<b>Application Ref:</b>	3/2026/0332			 <b>Ribble Valley Borough Council</b> <a href="http://www.ribblevalley.gov.uk">www.ribblevalley.gov.uk</a>
<b>Date Inspected:</b>	N/A	<b>Site Notice:</b>	N/A	
<b>Officer:</b>	AR			
<b>DELEGATED ITEM FILE REPORT:</b>				<b>PERMISSION NOT REQUIRED</b>

<b>Development Description:</b>	Certificate of Lawfulness for a proposed single-storey extension to rear.
<b>Site Address/Location:</b>	8 Lawson Place Barrow BB7 9GA

SHEET: PROPOSED PLANS

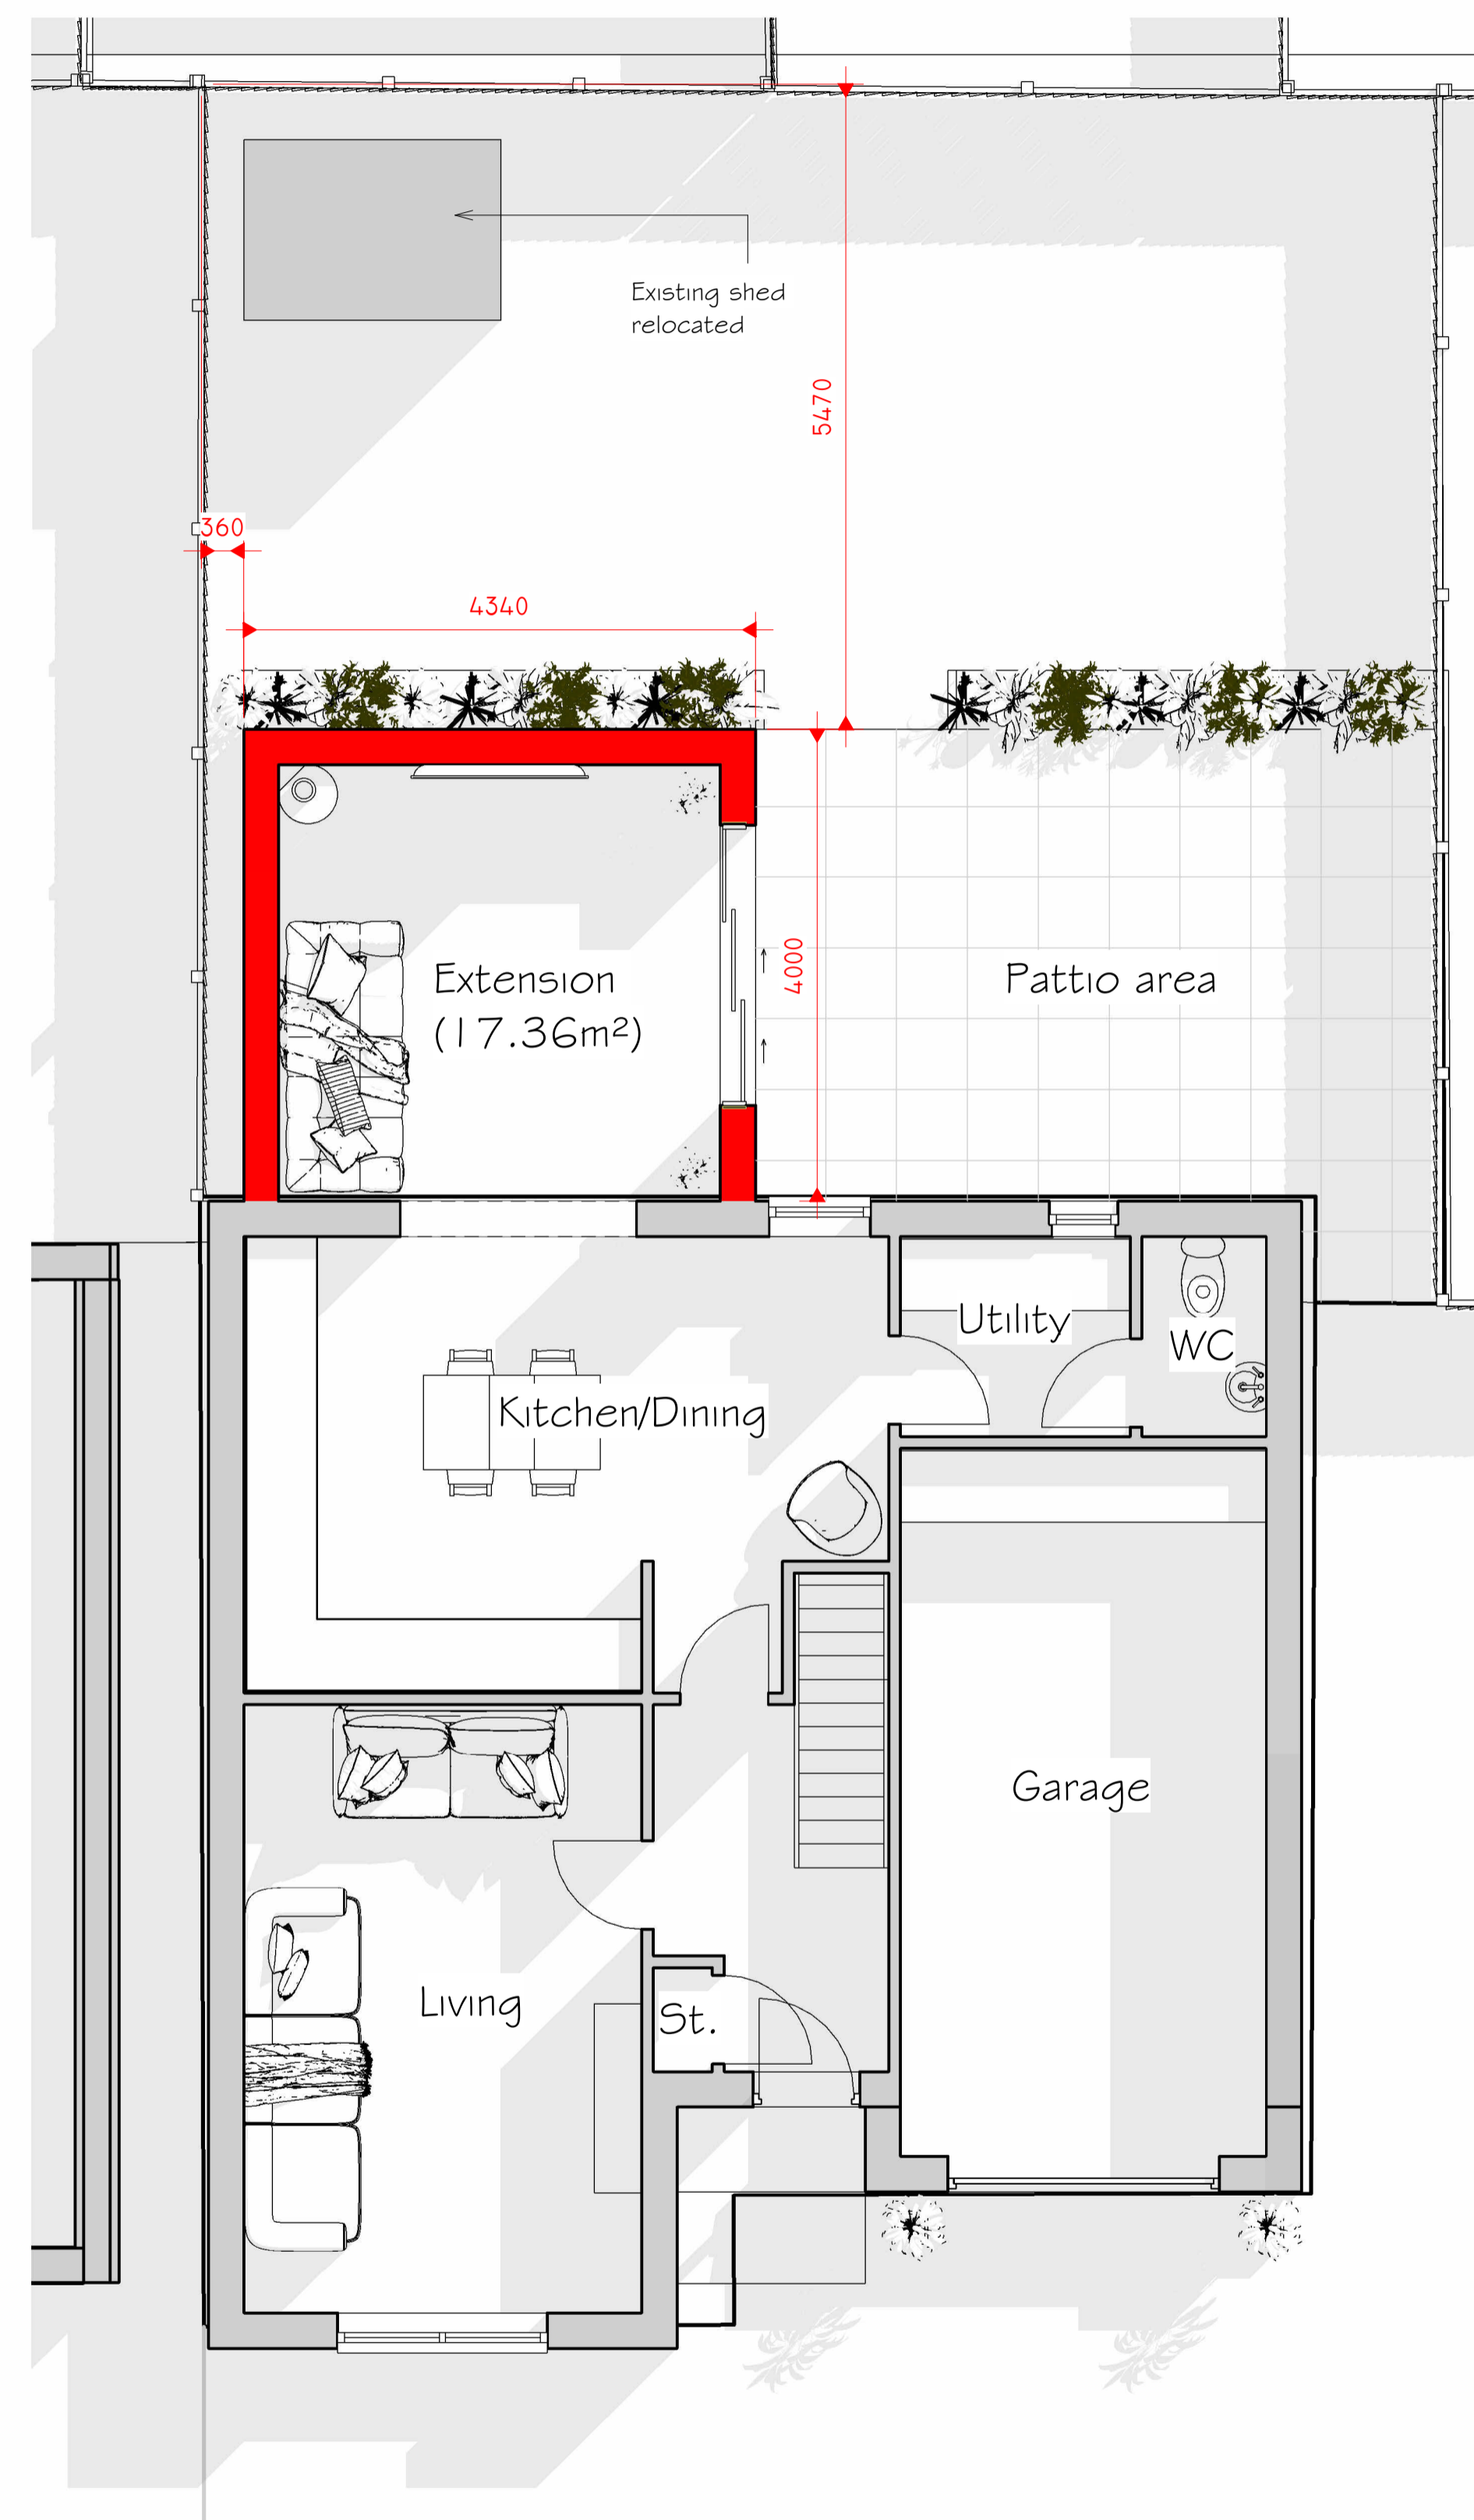
<b>ASSESSMENT OF PROPOSED DEVELOPMENT:</b>
<b>Site Description and Surrounding Area:</b>
The application relates to a detached two-storey dwellinghouse known as No.8 Lawson Place, located in Barrow. The surrounding area is a mixture of residential detached dwelling houses and open countryside. Aside from PROW FP8, which runs south of the application site, the site itself is not subject to any other specific designations or constraints.
<b>Proposed Development for which consent is sought:</b>
Consent is sought for the erection of a single-storey extension that projects out from the dwellinghouse's rear elevation by 4m, with a width of 4.3m, and an eaves and ridge height of 2.2m and 3.3m, respectively.

**The height of the proposed single storey extension would not exceed the height of the highest part of the roof of the existing dwellinghouse.**

**The height of the eaves of the proposed extension would not exceed the height of the eaves of the existing dwellinghouse.**

**The proposed extension would have a single storey and would not extend beyond the rear elevation of the original dwelling by more than 4m or exceed 4m in height.**

**The enlarged part of the dwellinghouse would be within 2 metres of the boundary of the curtilage, however the height of the eaves of the enlarged part would not exceed 3 metres.**

**The proposed extension would not extend beyond a wall forming a side elevation of the dwellinghouse.**

**The proposed extension would be finished in materials of a similar appearance to those used in the construction of the exterior of the existing dwelling house.**
